Application by Fosse Green Energy Ltd for an order granting development consent for the Fosse Green Energy solar farm

**Deadline 5 –
Comments on Submissions and
Information Received at Deadline 4**

North Kesteven District Council

28th April 2026

EN010154/APP/6.2.

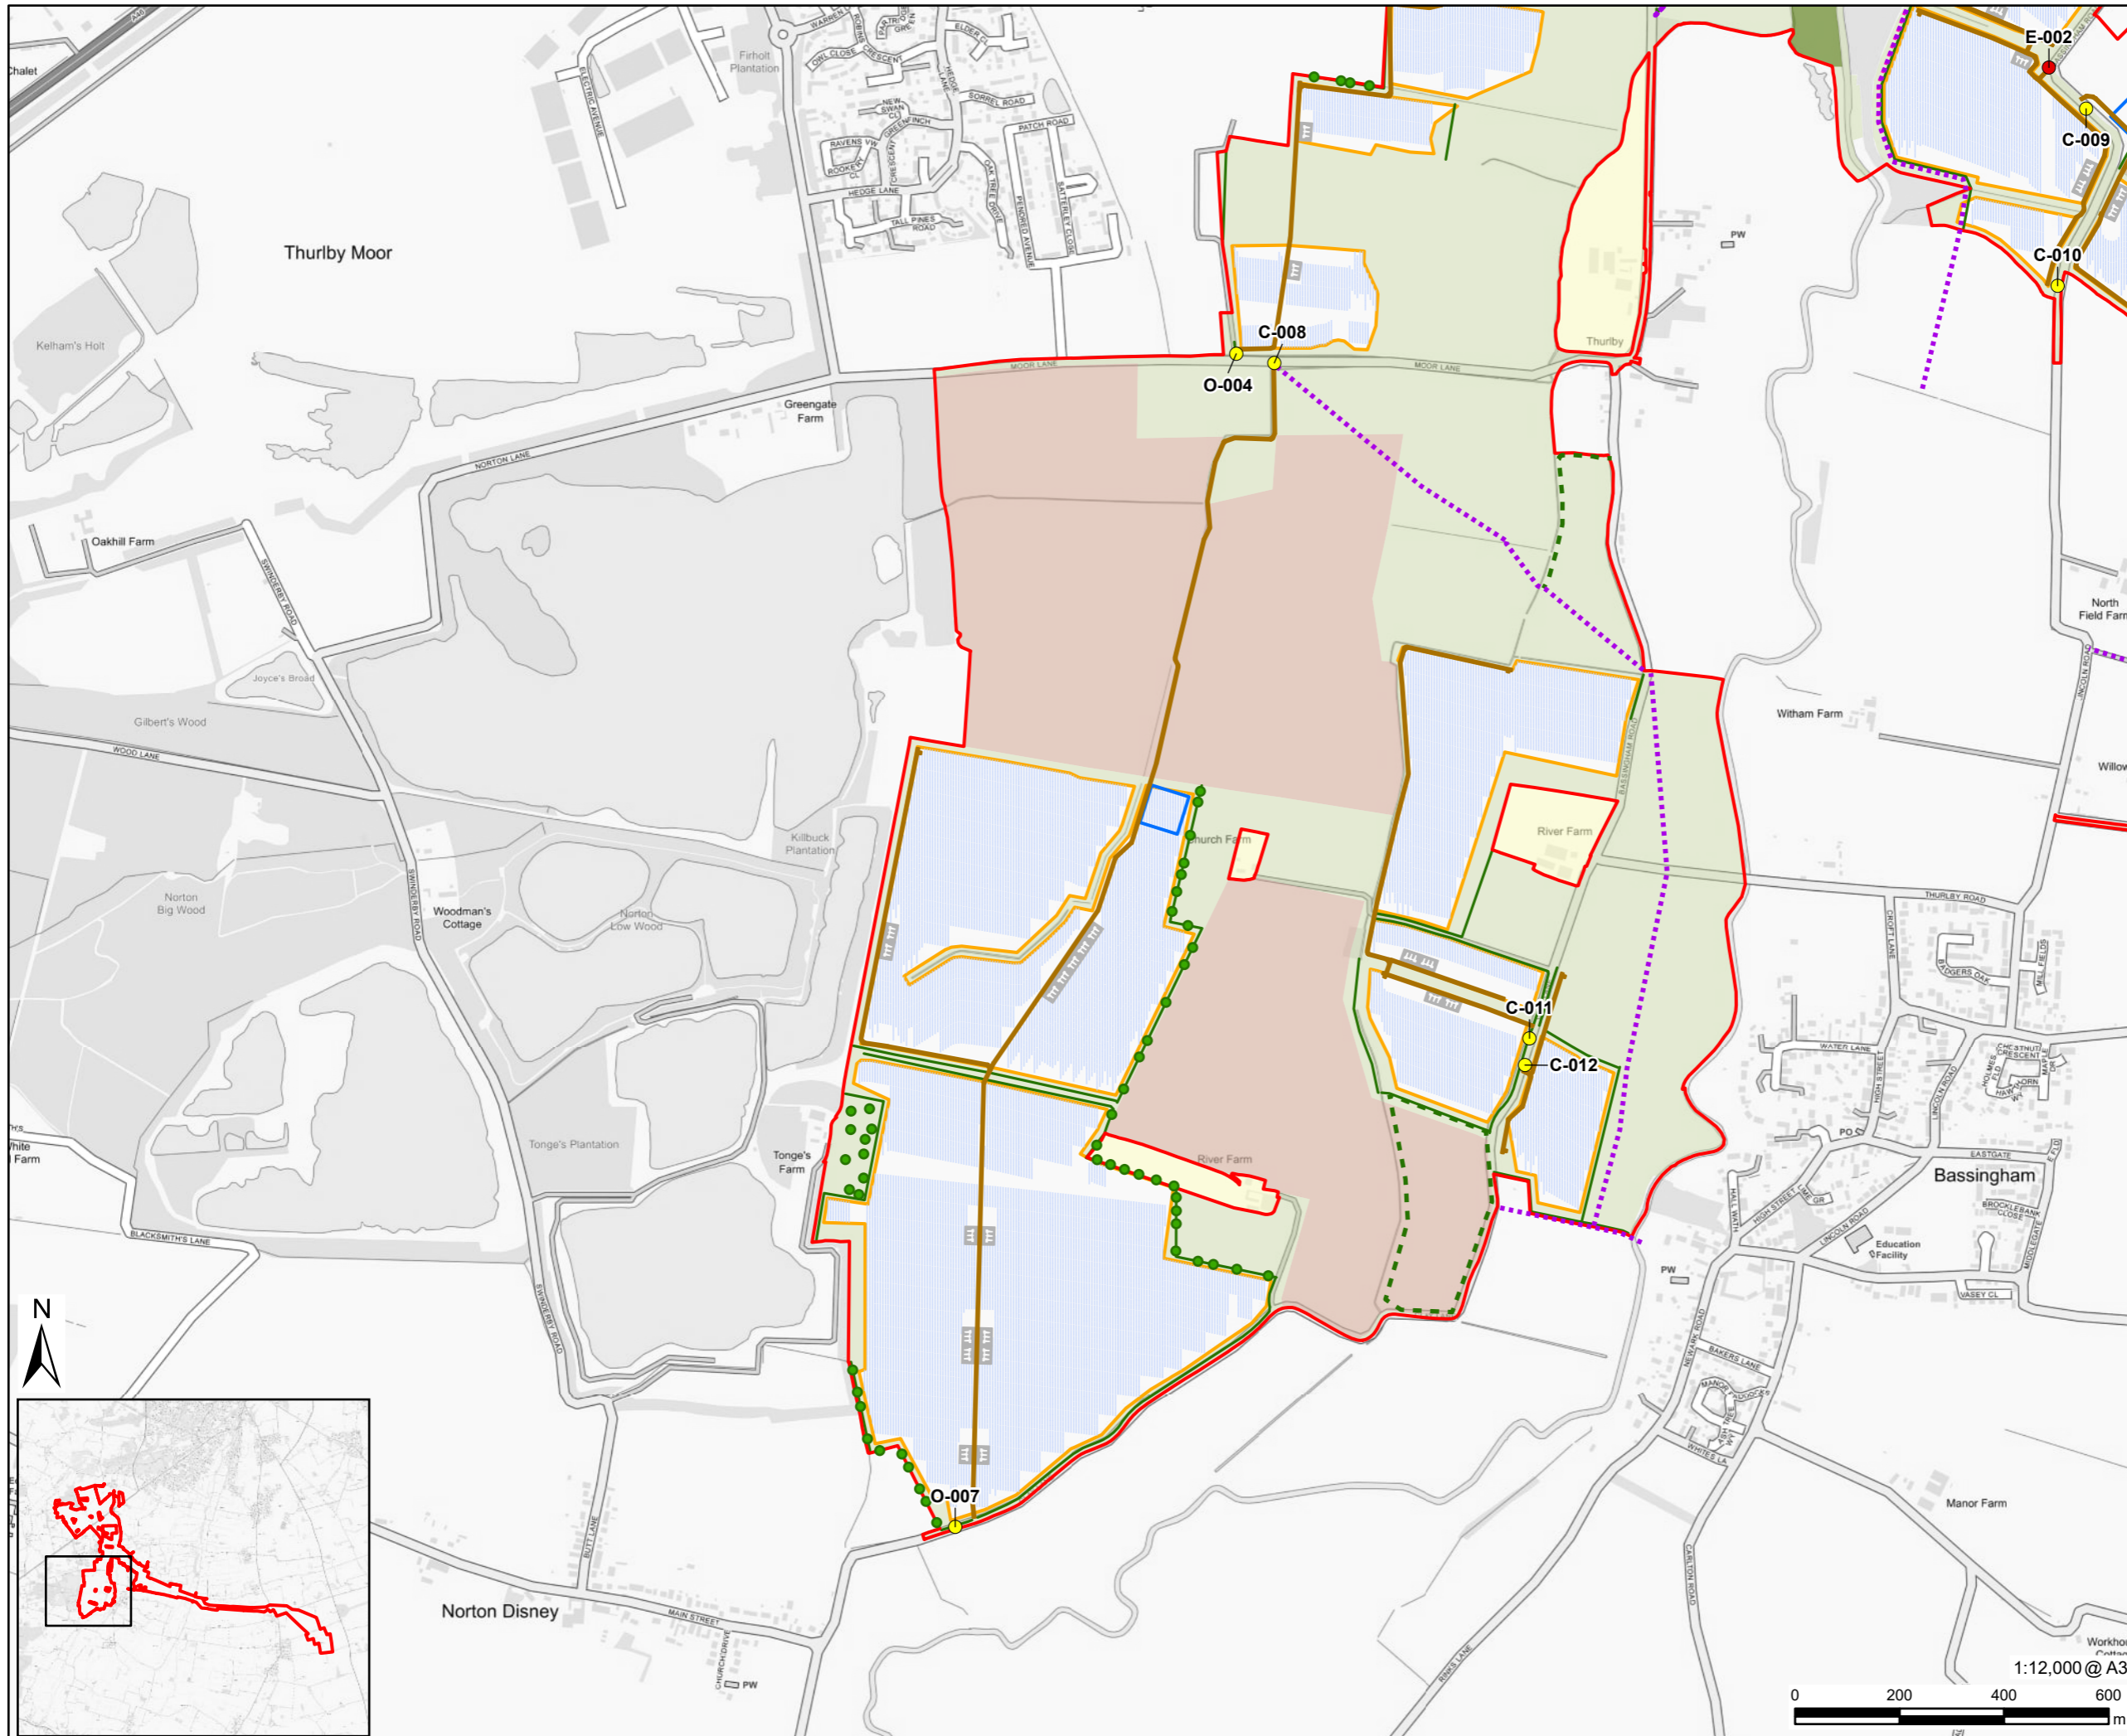
20. The Applicant has submitted the following drawings as indicating its revised approach to the provision of permissive paths:
 - REP4-006 : Figure 3-2A Indicative Fixed South-facing Site Layout Plan

- REP4-007 : Figure 3-2B Indicative Single Axis Tracker Site Layout Plan
21. These drawings are labelled 'indicative', and are not intended to be certified documents. The Council looks forward to having sight of the final permissive path proposals on the Landscape Mitigation Plan contained in the Framework Landscape and Ecological Management Plan, as it is that document which is referred to in the definition of Permissive Paths in the draft DCO, article 2 (REP3A-029). Also showing the permissive paths on the Streets, Rights of Way and Access Plans will be helpful in showing how they connect to the statutory public rights of way network.

23. The changes to the permissive path routes in the area around Thorpe on the Hill, Morton and Tunman Wood represent an overall minor improvement on previous

proposals. The loss of some lengths of the existing Stepping Out permissive routes – for instance the valuable walk along the southern side of Housham Wood – is offset by the retention of the length of permissive path alongside the eastern side of the wood north of Housham Wood Farm. The new route also avoids “funnelling” walkers between panel arrays heading south from Housham Wood; but on the other hand the loss of a length of permissive path to the east of Housham Wood Farm means directing walkers along the public rights of way immediately to the north, where they would have to pass between areas of panel arrays.

24. These changes do not significantly reduce the adverse effects on the experience for users of the two Stepping Out Walks: Morton and Tunman Wood, and Thorpe on the Hill. It is clear that users would experience the loss of open, undeveloped and wide rural views – a major factor in the design and promotion of these walks. The Applicant has never properly acknowledged the value of these walks in terms of their potential to deliver on recreation, mental and physical health, and tourism objectives. Those effects need to be fully mitigated and compensated for.

25. In terms of the total length of permissive path offered, the Applicant has measured this to be 10.2km. Whilst there are limitations with the scale and accuracy of the plans provided, the Council has measured the total length of permissive path as being 9.8km. But in any case, there are significant limitations to the Applicant’s approach which this highlights. Whilst the provision of permissive paths in general is welcome, the failure to recognise the value of and impacts on the Stepping Out Walks in particular is a deficiency of the application. For instance, the permissive path proposed alongside the A46 may be of value to some, especially the occupants of the caravan park nearby. However, in terms of views and noise, that path would never have been selected as part of a Stepping Out Walk.
